# **M60/M62/M66 Simister Island Interchange**

**TR010064**

## **7.13 APPLICANT'S RESPONSES TO RELEVANT REPRESENTATIONS**

<b>Version</b>	<b>Date</b>	<b>Status of Version</b>
P01	24 September 2024	Deadline 1

**Plate 2.9 Conceptual site model for Parkwood Cottages South**

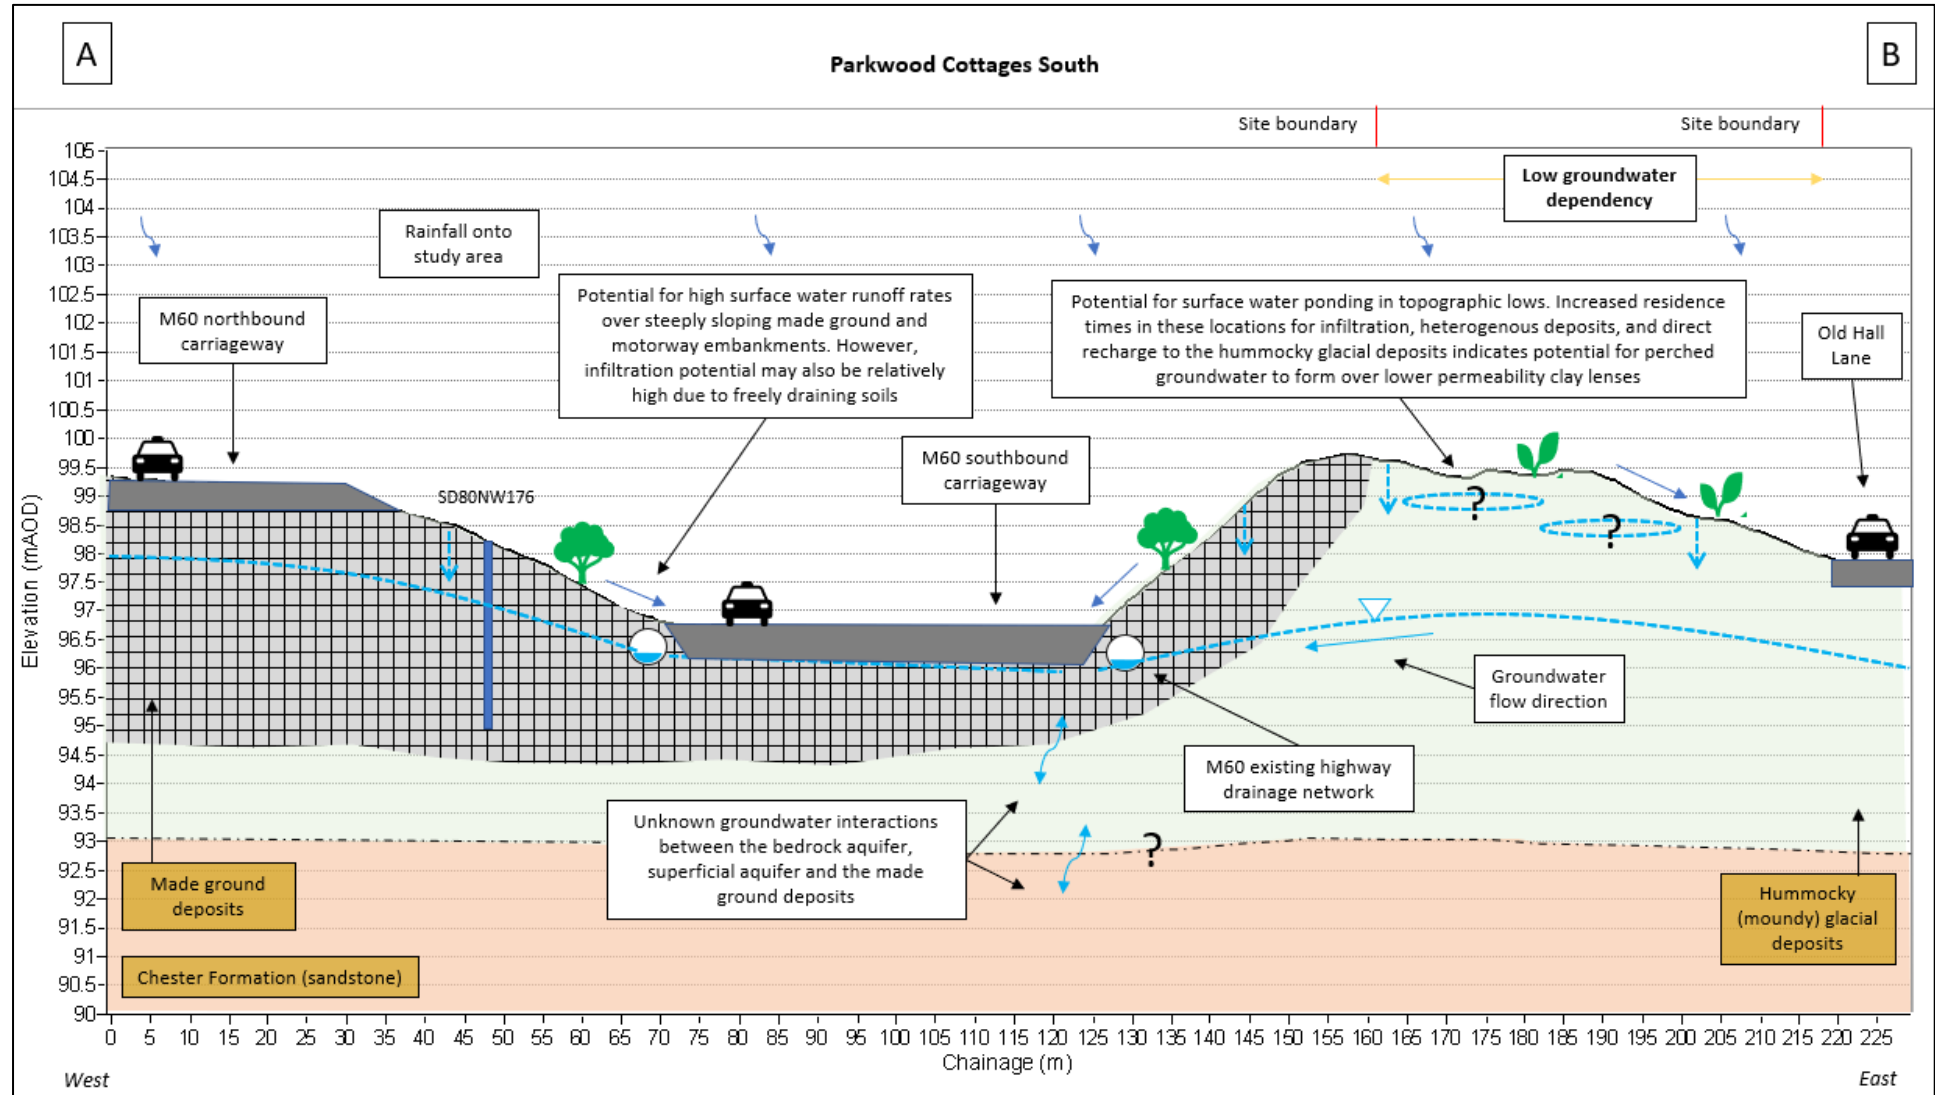
RR-004e	<i>The conceptual models have shown that there are connections with the groundwater dependent terrestrial ecosystems as shown in the report. The HERWAT assessment considered in Appendix 13.2: Water Quality Assessment Report of the Environmental Statement Appendices (TR010064/APP/6.3) does not look at impacts to groundwater. If any changes are made and discharges are to be made to groundwater, then a water quality assessment must be completed in line with the SUDS manual (C753) to determine the risks and mitigations required for groundwater quality. This is especially important because of the presence of nearby groundwater dependent terrestrial ecosystems.</i>	Please refer to the response provided in the agreed Statement of Common Ground with the Environment Agency [TR010064/APP/7.11].
RR-004f	<i>We note under Chapter 9 (Geology and Soils) of the Environmental Statement that there is an intention to produce a Detailed Quantitative Risk Assessment (DQRA) to establish risks of contamination from the proposed development to 'controlled waters'. Following the production</i>	Please refer to the response provided in the agreed Statement of Common Ground with the Environment Agency [TR010064/APP/7.11].
